Application for a Non-Material Amendment Following a Grant of Planning Permission

Land adjoining and east of Last House adjoining and north of Berry Hill Road, Adderbury

Discharge of Conditions 14 (arboricultural protection), 17 (landscaping), 18 (landscape management) and 20 (air quality assessment) of 19/00963/OUT (granted consent under appeal Ref: APP/C3105/W/20/3255419)

22/03437/DISC

scheme: Land off Berry Hill Road,
Alderbury, Banbury
client: Hayfield Homes
drawing: Landscape Proposals
date: March 2022
scale: 1:200@A1
drawing no: HAY23648-11H Sheet 3 of 3
drawn: SR checked: JC

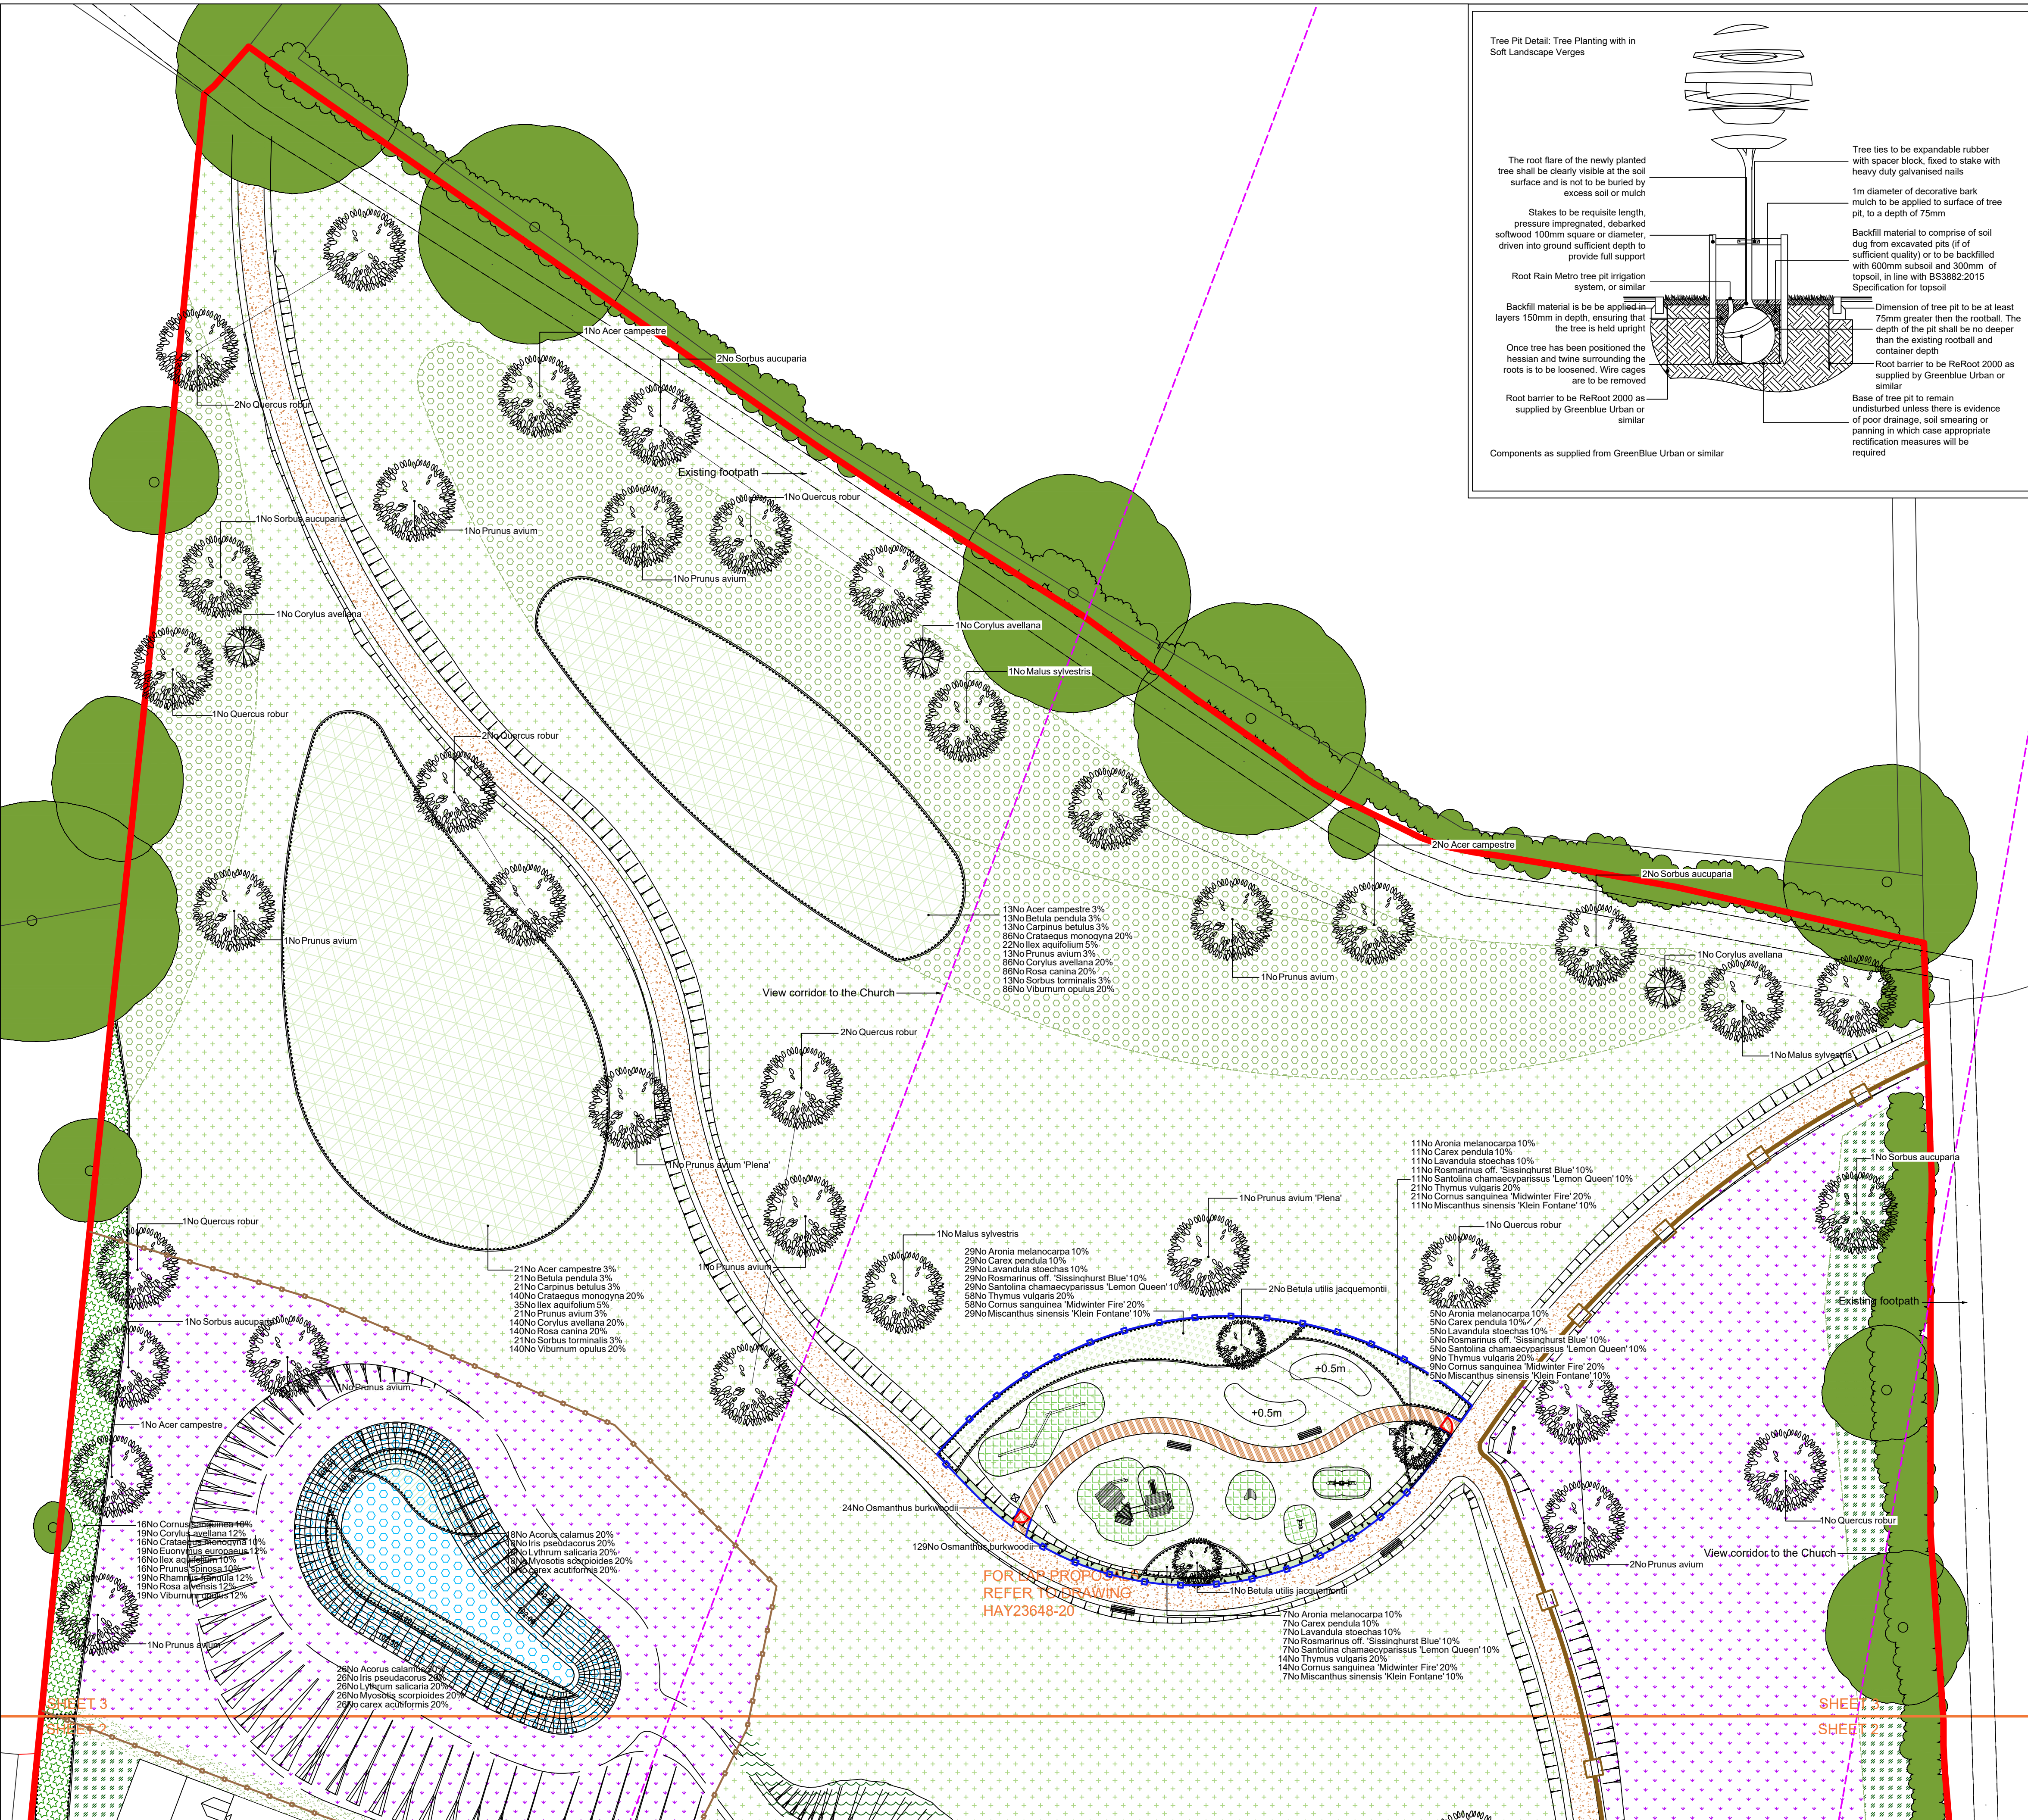
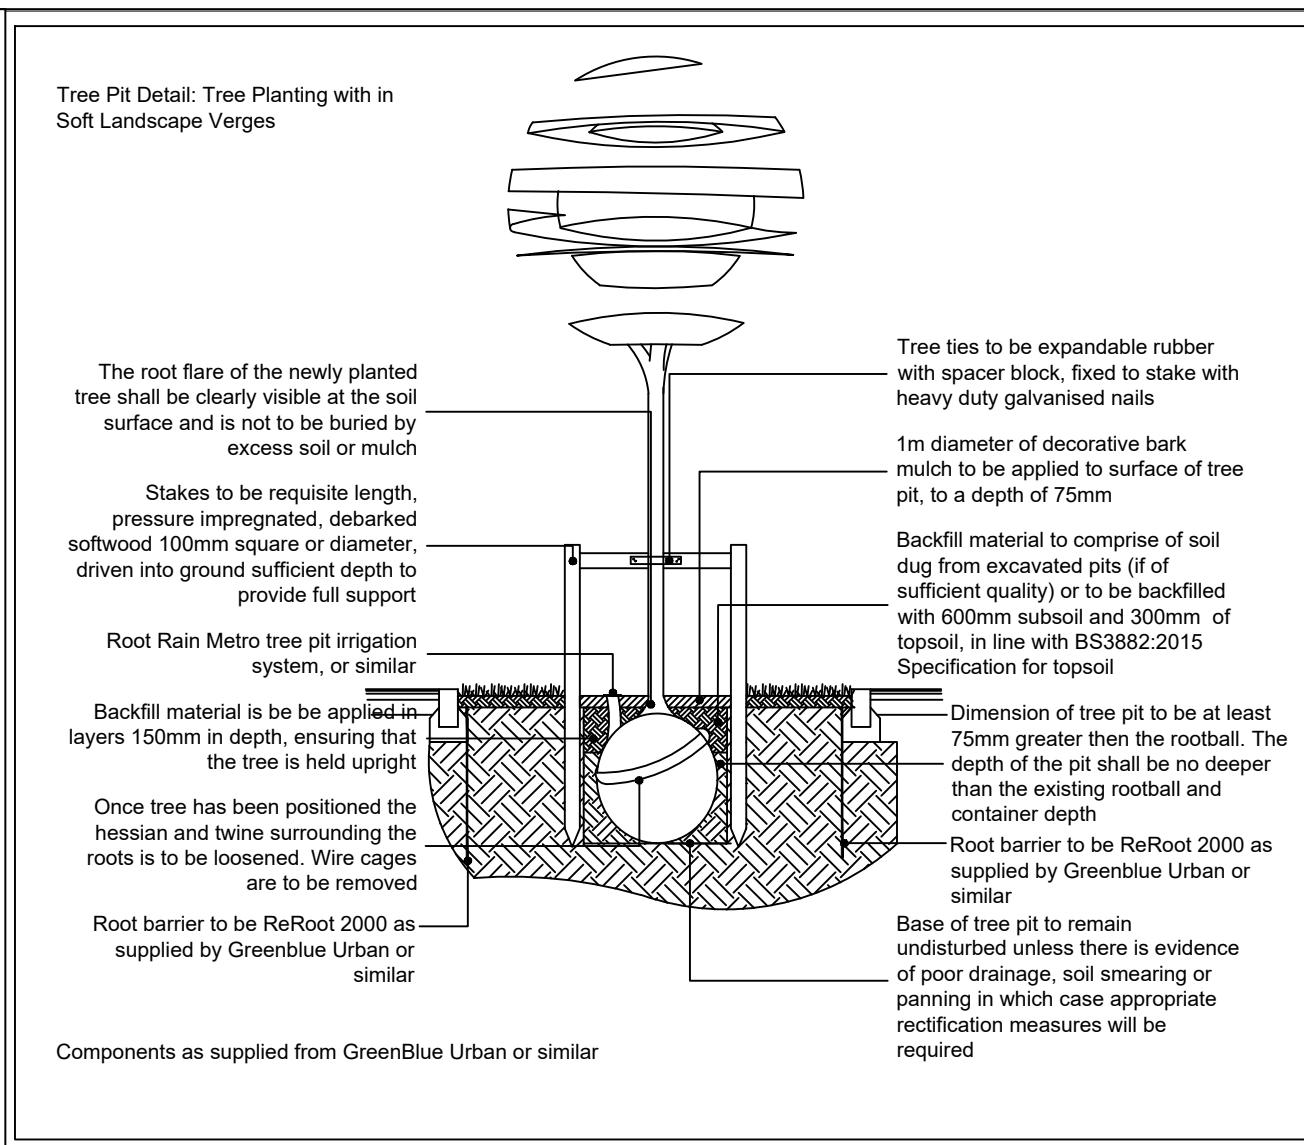
This application relates to the minor changes proposed to the landscaping details, to replace the timber knee rail around the area of 'EM2 Standard General-Purpose Meadow Mixture' with a 1.0m high stock-proof timber post and rail fence, along the eastern edge of the development.

This will restrict public access, to enable the target habitat condition to be achieved, to facilitate a net gain in biodiversity.

HAY23648/11H Landscape Proposals: Sheet 3 of 3
